# **KITTITAS COUNTY**

**TO:** All Staff  
**FROM:** Public Works Plan Review Team  
**DATE:** November 5, 2024  
**SUBJECT:** BL-24-00022 Palmer Linder

RECORD OF SURVEY
PARCEL NO'S. 024334 & 244334
PREPARED FOR
4963 NANEUM, L.L.C.

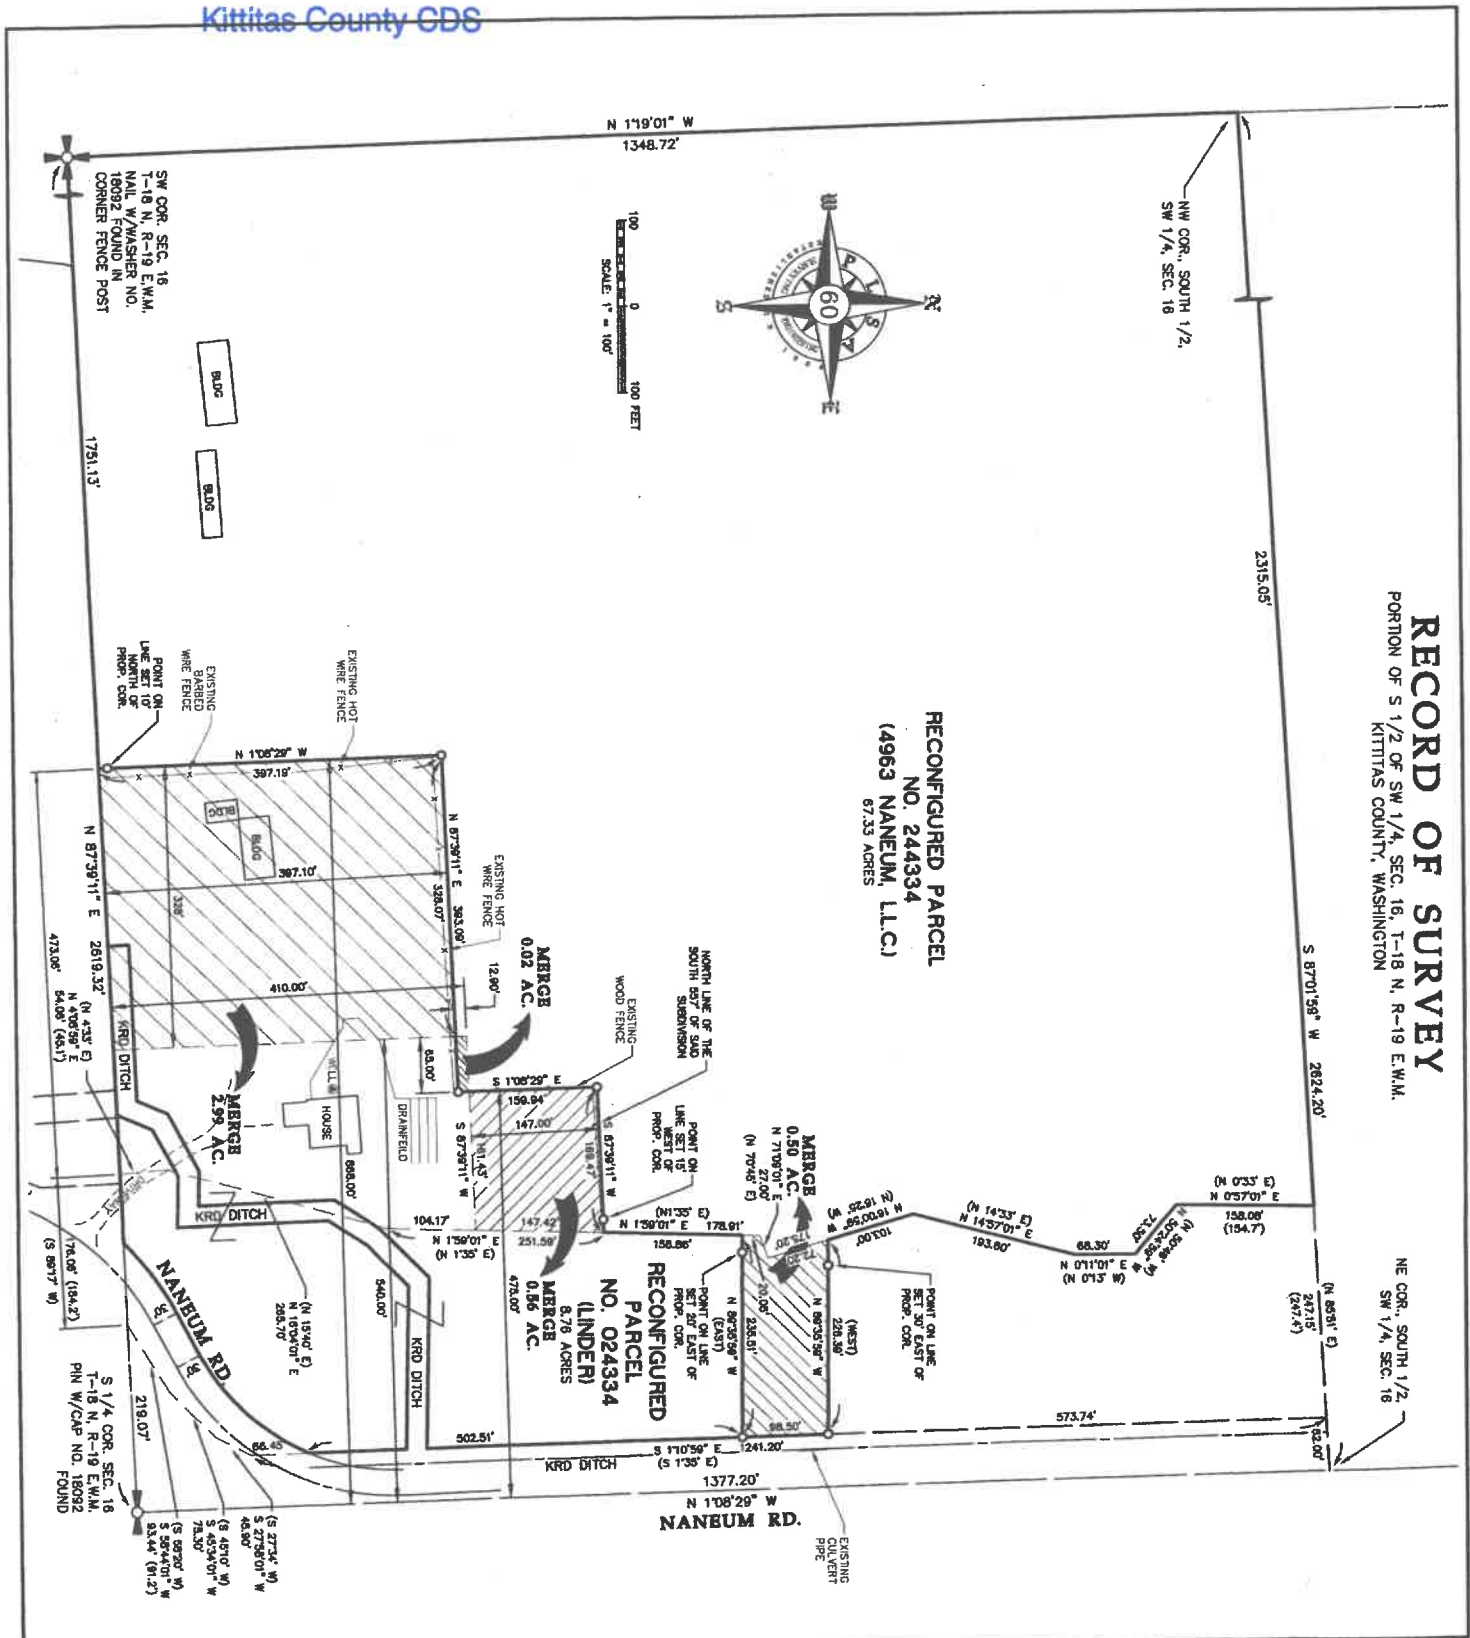
<b>ACCESS</b>	<ol style="list-style-type: none"><li>1. Parcel 024334 has an approved agricultural access permit AC-24-00032. Change in use will require a new access permit.</li><li>2. Road Variance RV-24-00005 to waive access spacing requirements was approved.</li><li>3. Maintenance of driveway approaches shall be the responsibility of the owner whose property they serve. The County will not maintain accesses.</li><li>4. Any further subdivision or lots to be served by proposed access may result in further access requirements. See Kittitas County Road Standards Title 12.</li><li>5. In addition to the above-mentioned conditions, all applicable Kittitas County Road Standards apply to this proposal. Access is not guaranteed to any existing or created parcel on this application. (JS)</li></ol>
<b>ENGINEERING</b>	<p>Except as exempted in KCC 14.05.060, no grading or filling upon a site involving more than one hundred (100) cubic yards shall be performed without a grading permit from the County Engineer or Public Works designee (KCC 14.05.050). An application for grading in excess of five hundred (500) cubic yards shall be accompanied by an engineered grading plan (KCC 14.05.080).</p> <p>The record of survey is unclear where the 0.04 acre from parcel number 244334 to parcel number 024334 is coming from. This number doesn't match what was given in the application. The 2.99 ac section that is being merged also seems like that is already existing on parcel 024334.</p>

<b>FLOOD</b>	A portion of parcel # 244334 is located within the FEMA identified special flood hazard area (100-year floodplain). If possible, any future development should remain outside of the floodplain in order to reduce risk and avoid mandatory flood insurance purchase requirements. All activities within the floodplain must be permitted through the floodplain development permit process and follow the regulations within KCC 14.08. (SC)
<b>WATER MITIGATION/ METERING</b>	No comments. (SC)
<b>AIRPORT</b>	No comments (JS)
